Re: Planning Application 18/0915

Address: Daniels Farm Preston Road Alston Preston PR3 3BL.

Description: Application for outline planning permission with some matters reserved for a residential development of 3 dwellings, following demolition of agricultural buildings including access.

Indicative Block Plan
scale 1:500

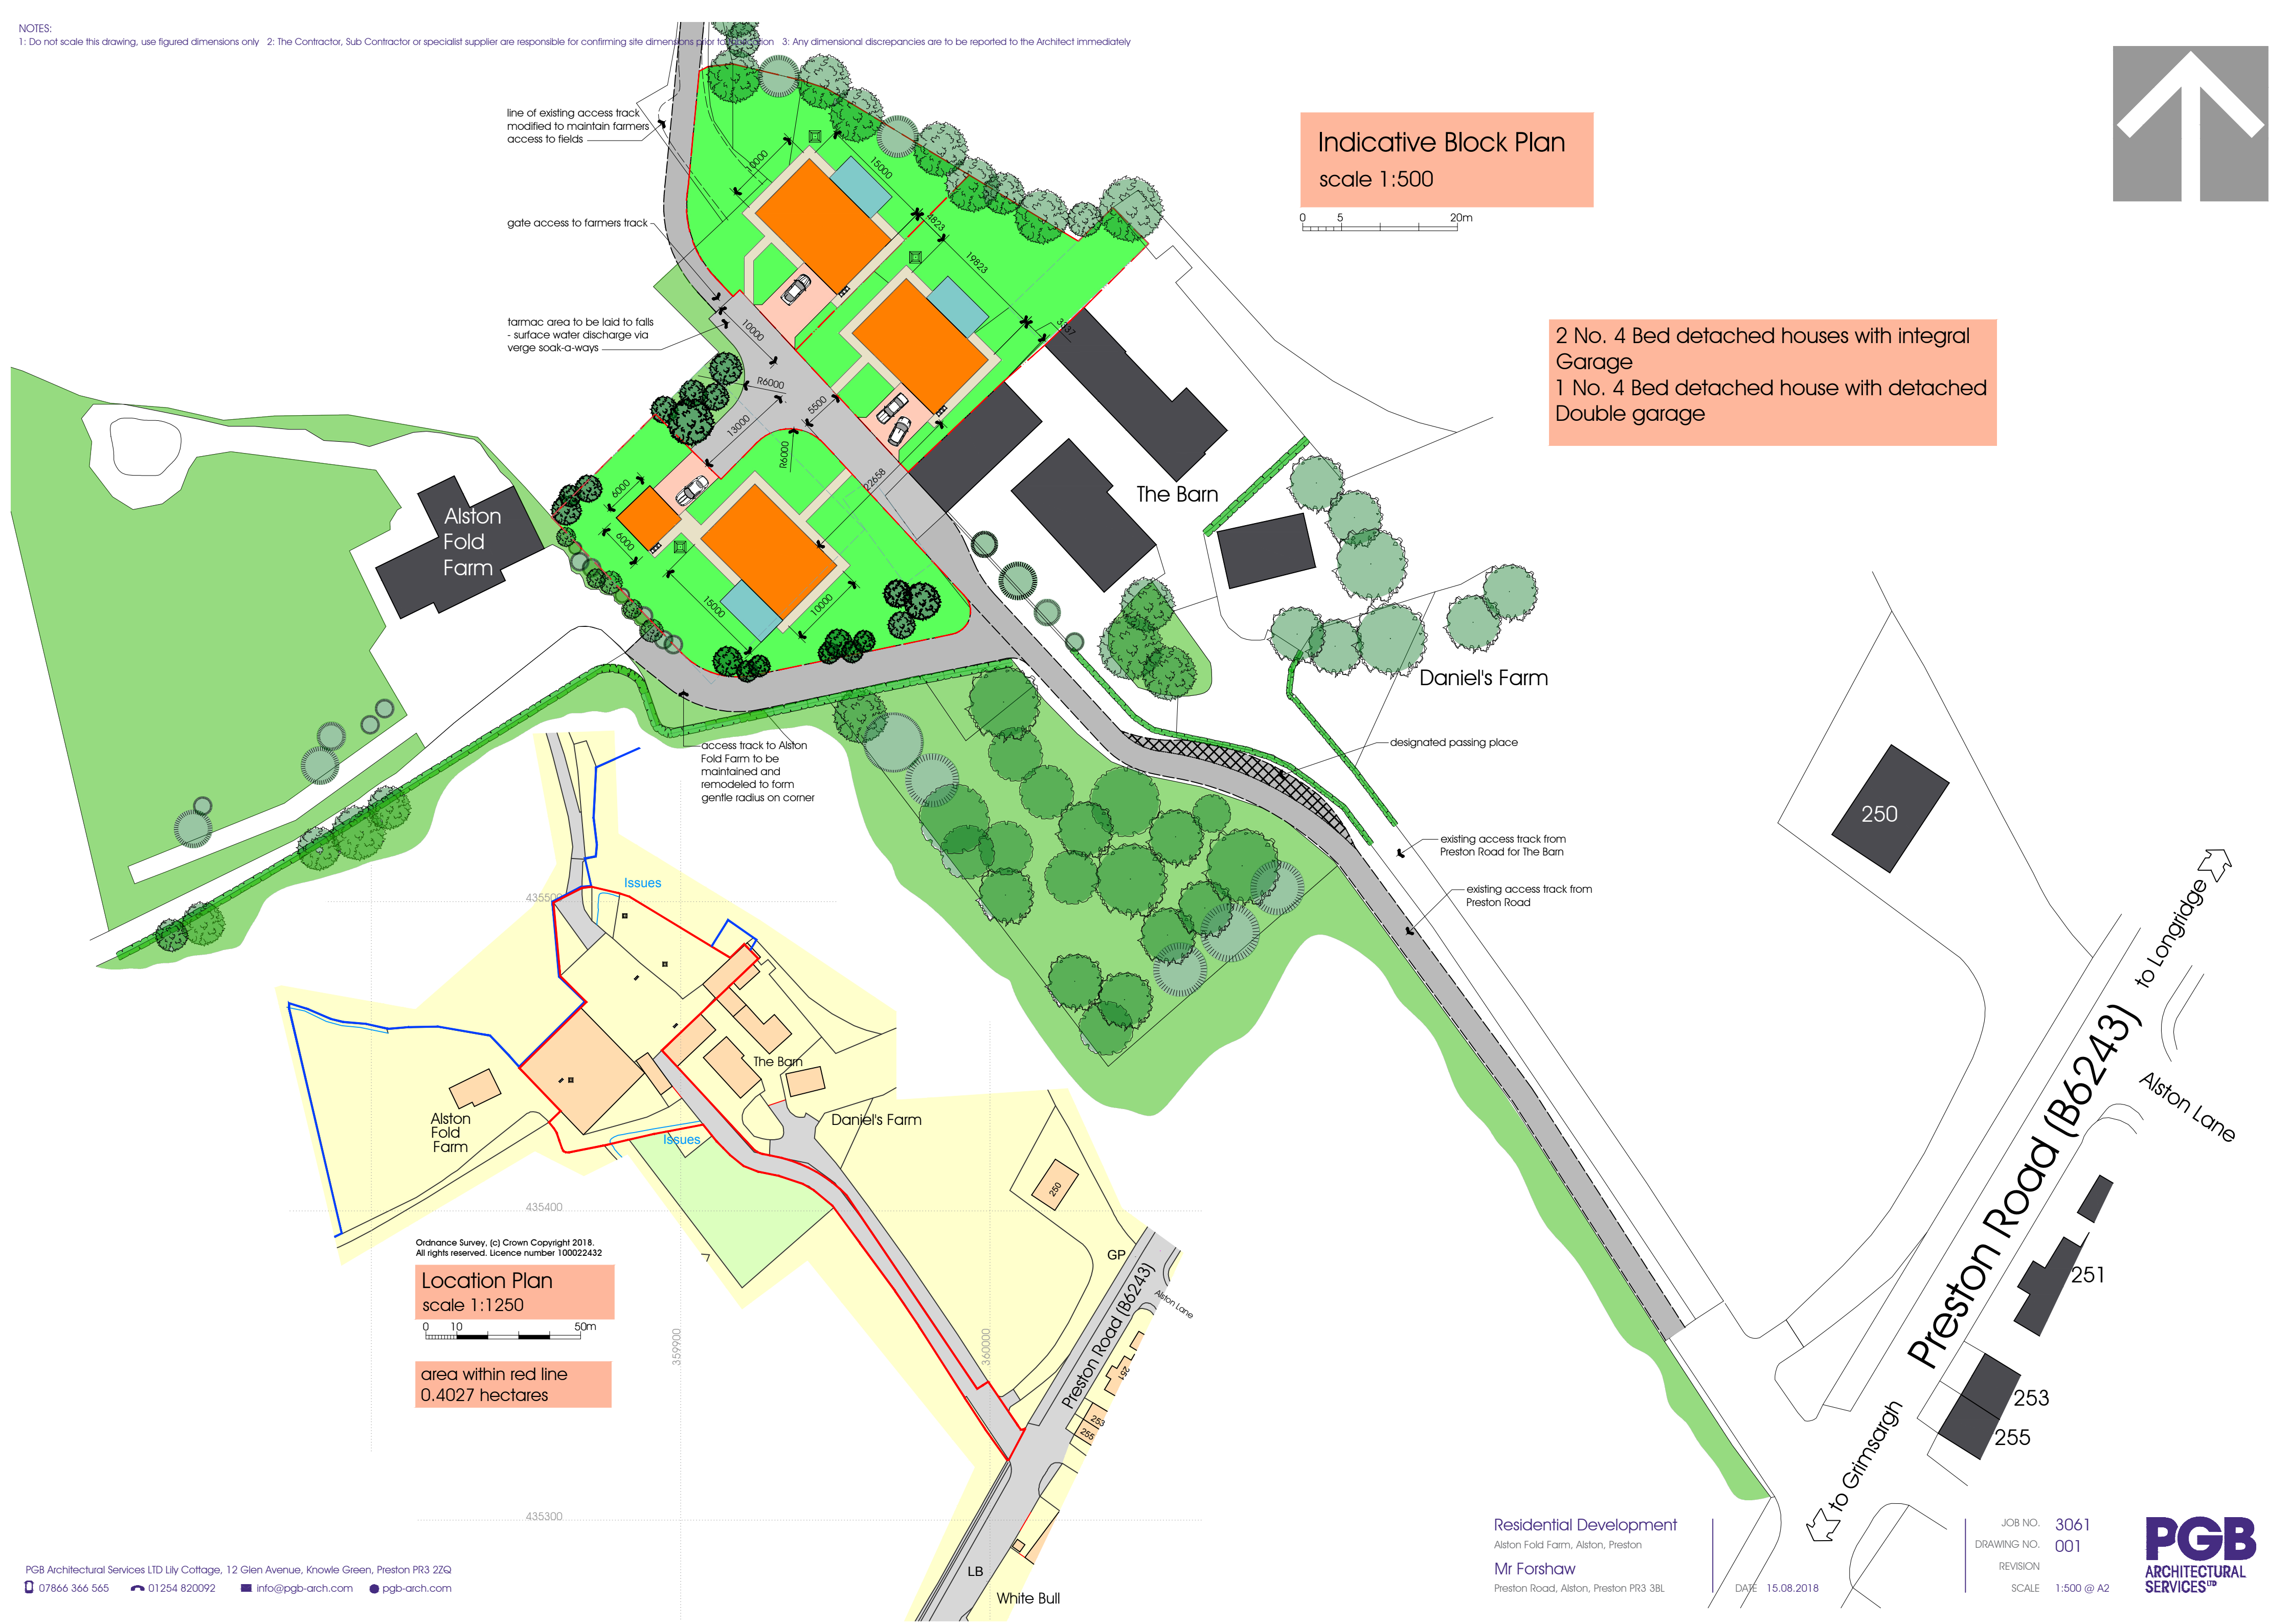
It should be noted that the additional 3 properties will raise the total number in the development cluster to more than 5. It is therefore recommended that the access road should be built to an adoptable standard and should be put forward for adoption.

2. Where constructed single garages should have minimum dimensions of 6 x 3 metres". The Highway Development Control Section is therefore of the opinion that where garages are smaller than the recommended minimum internal dimension of 6 x 3m they should not be counted as a parking space and the applicant should provide an additional parking space for each garage affected.

3. It is recommended that all private drives fronting garages to be a minimum of 6m long and this must not include any of the required 2m wide service verge. The drive length can be reduced to 5.5m if roller shutters are fitted and conditioned as part of the planning decision. The minimum dimension for a single drive should be 2.4m wide and single private drives to have a minimum width of 3.2m where they are used for vehicular access and pedestrian access to the property.

4. The parking requirement for a four/five bedroom house is for three off road parking spaces.
5. All off road proposed car parking spaces to have 6m manoeuvring space to prevent over running of the opposite footpath, collisions with property and vehicles etc. and to ensure highway safety and maintenance is not significantly affected by the movements. Alternatively prove the turning area by swept path analysis for each parking bay.
